Popeley Farm, Gomersall – Addendum to structural inspection report for planning (Barns 1 & 2)

Description: For client and planning approval

Project: Popeley Farm
Client: Mr. J. Clay
Description: Structural Inspection
Date: 1st October 2024

client:	Knabbs Ash Barn Ltd
project:	Class Q Planning Application
location:	Popely Farm, Muffit Lane, Gomersal BD19 4QS
drawing title:	Unit A (B2) North & West Facing Elevations
date:	31/07/23 drawn: jszn scale @ A3: 1:100 job no: 23.111
drawing no:	1109 revision: B

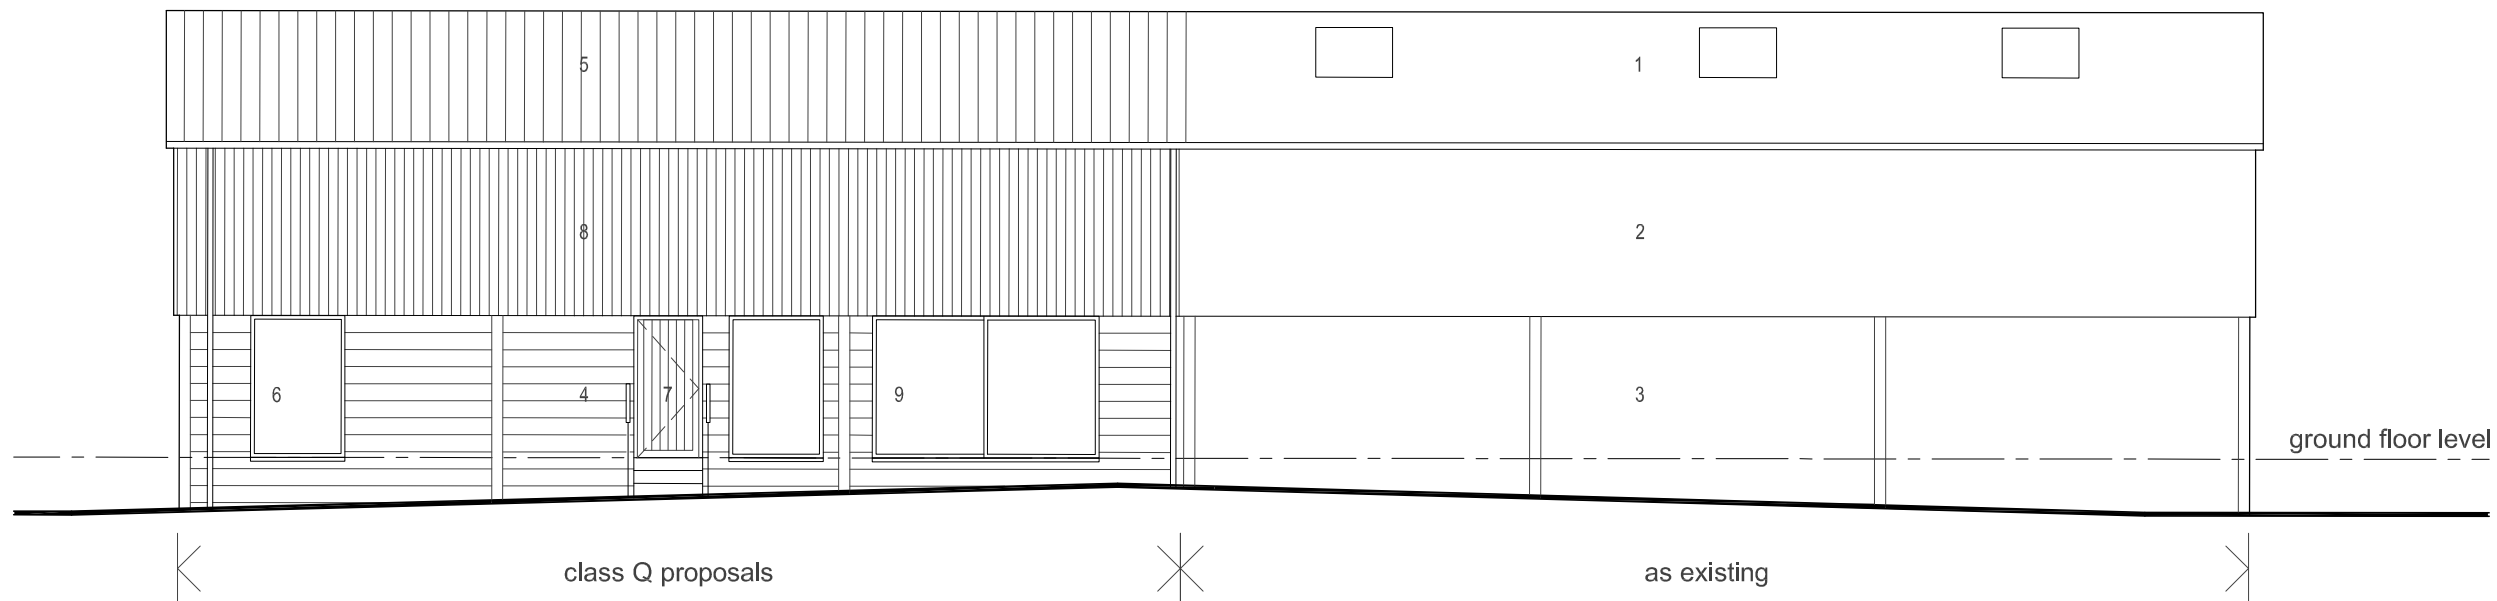
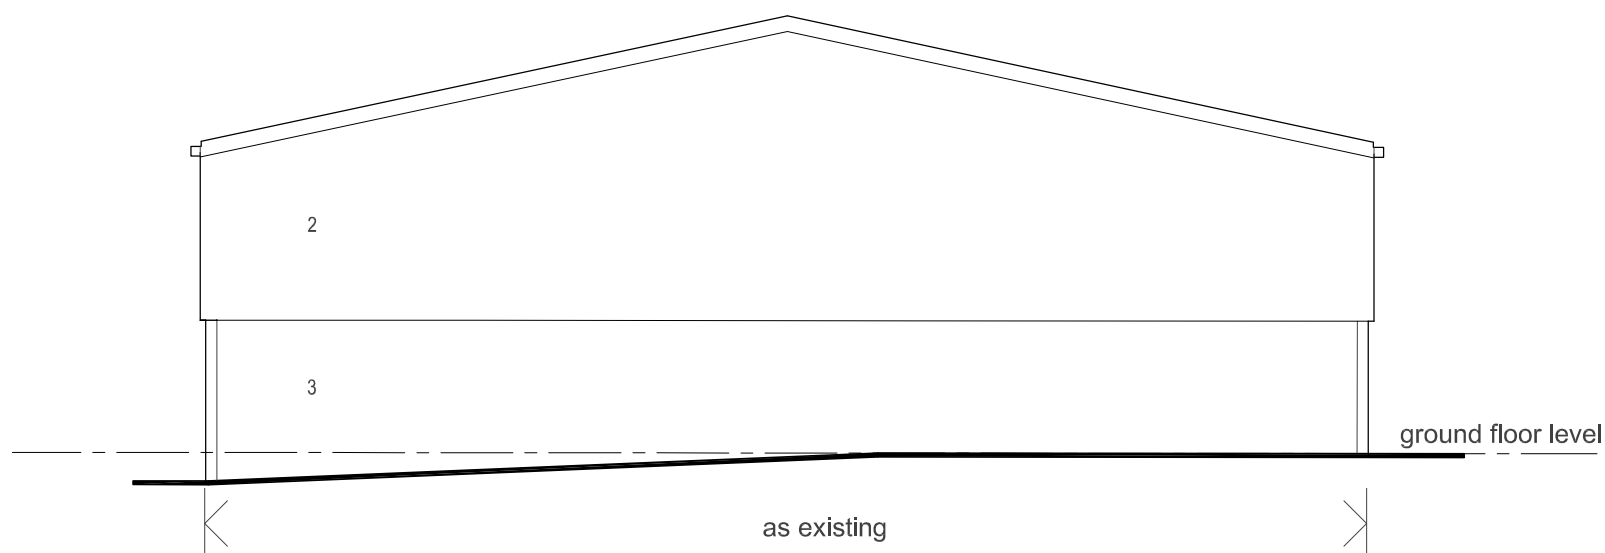
We have become aware of changes to the proposed building envelope of both barns which involves retaining the / installing profiled steel cladding and roof sheets to form the weatherproof building envelope.

- 23.111.1109A – Unit A Elevations As Proposed (003).pdf
- 23.111.1209A – Unit B Elevations As Proposed (003).pdf
- 23.111.1210A – Unit B Elevations As Proposed (003).pdf

- Once repaired, made good and sealed for continued use, the profiled sheets to the walls and roof will be a similar weight to what is currently being supported by the steel frames. Assuming new elements such as insulation, membranes etcetera can be arranged independently of the sheets, the overall loading on the frames will be largely unchanged, which implies that the steel frames would remain suited without further modification. (Refer to the first bullet point in the introduction section above).

- The existing steel frames lack any formal bracing for stability. To date, the lateral stiffening has been taken care of by virtue of the 'stressed skin / diaphragm'¹ action of the cladding sheets, and this function may be assumed to continue in the future if the sheets are retained. Lateral stiffening is less of a concern in the updated scheme since the profiled steel envelope is much more tolerant to movements arising from lateral forces and the roof sheets are likely to form a diaphragm to transfer any lateral loading to the very stiff gable panels to manage

- Retain/reinstall/install the profiled steel cladding and roof sheets, with sufficient connection to the primary steel frames and between the sheets to develop a stressed skin / diaphragm bracing effect to stabilise the frames.
- Checks on any cement fibre type roof sheets / cladding present for asbestos before starting works.
- The unknown foundations and the soil they bear upon should be exposed during works and confirmed for suitability.
